CITY OF PORTLAND, MAINE
DEVELOPMENT REVIEW APPLICATION
PLANNING DEPARTMENT PROCESSING FORM
DRC Copy

2005-0236
Application I. D. Number
10/12/2005
Application Date
Ruby Lane #14
Project Name/Description

November 9, 2005

RE: Application for Single Family Residences, Ruby Lane lots #13 and lot #14

FIGURE
 14-B

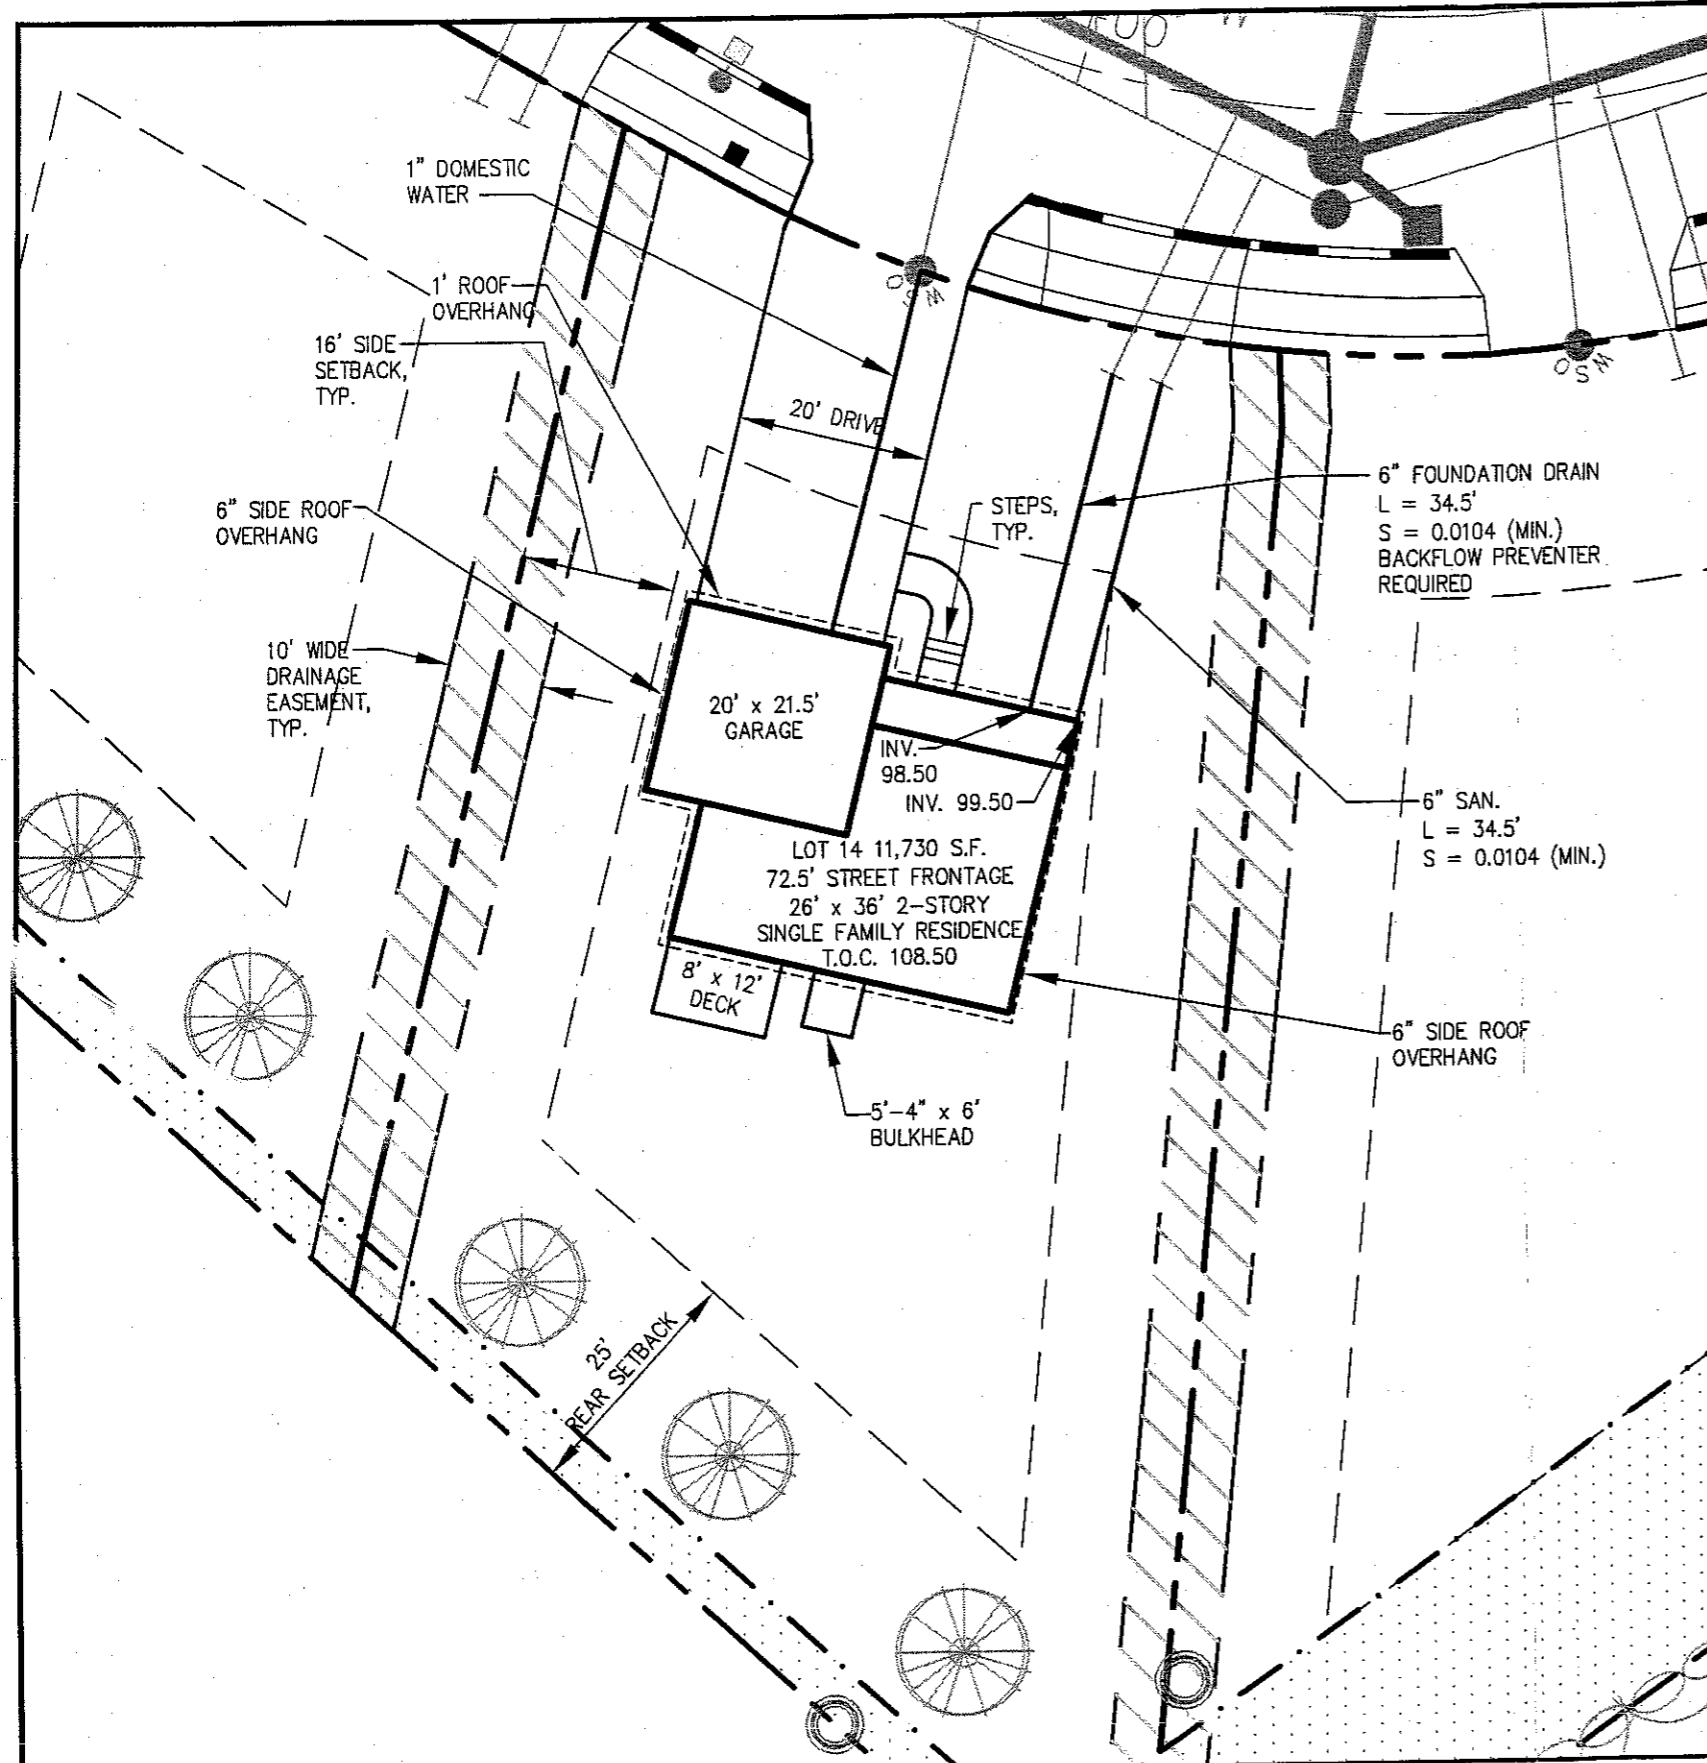
1. Please add two street trees to your plan.
2. Same items listed above (2., 3., and 4.).
